From: Iain Osenton <iain.osenton@cherwell-dc.gov.uk>
Sent: Wednesday, October 23, 2019 2:13 PM
To: James Kirkham <James.Kirkham@Cherwell-DC.gov.uk>
Cc: Planning <Planning@Cherwell-DC.gov.uk>; dcregistration <dcregistration@Cherwell-DC.gov.uk>
Subject: 19/00616/OUT - CDC Arboriculture

Regarding the above referenced application from desk based assessment.

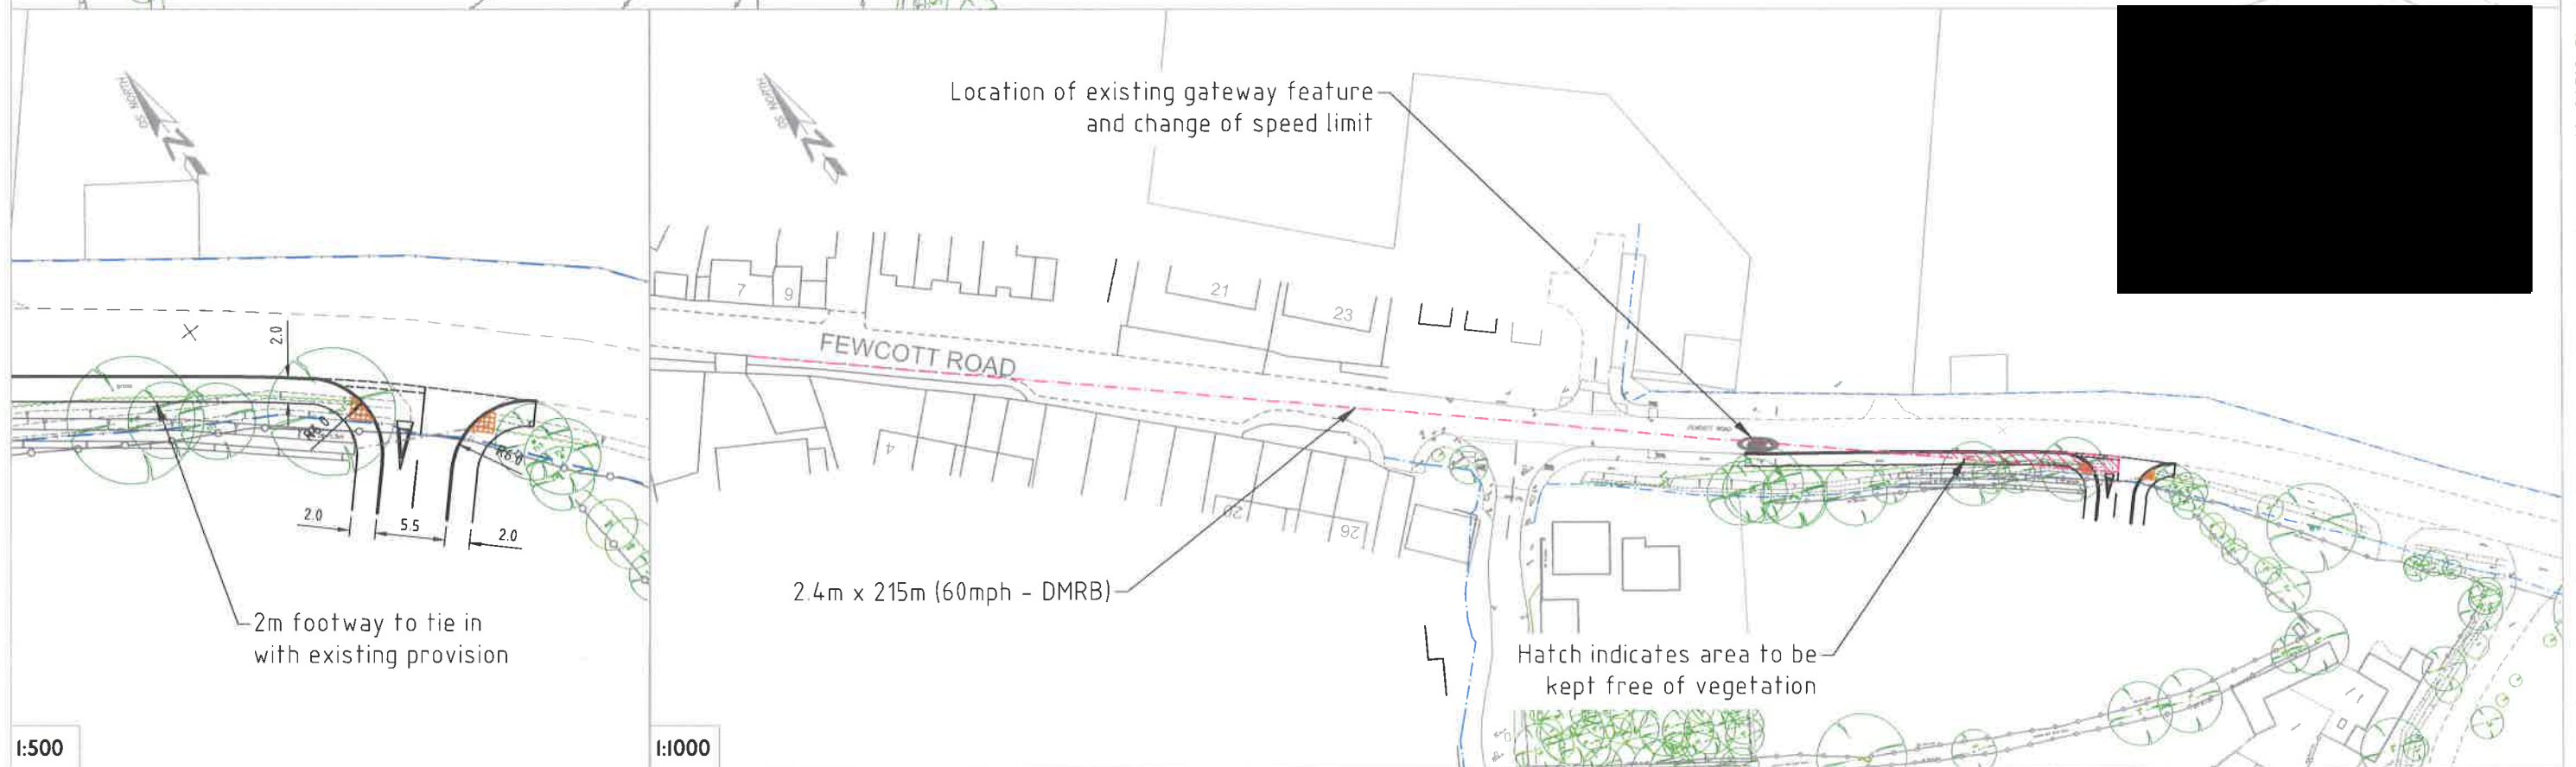
The amended site layout has lessened concerns previously held against the site entrance and vision splays, and plots to the south of the site.
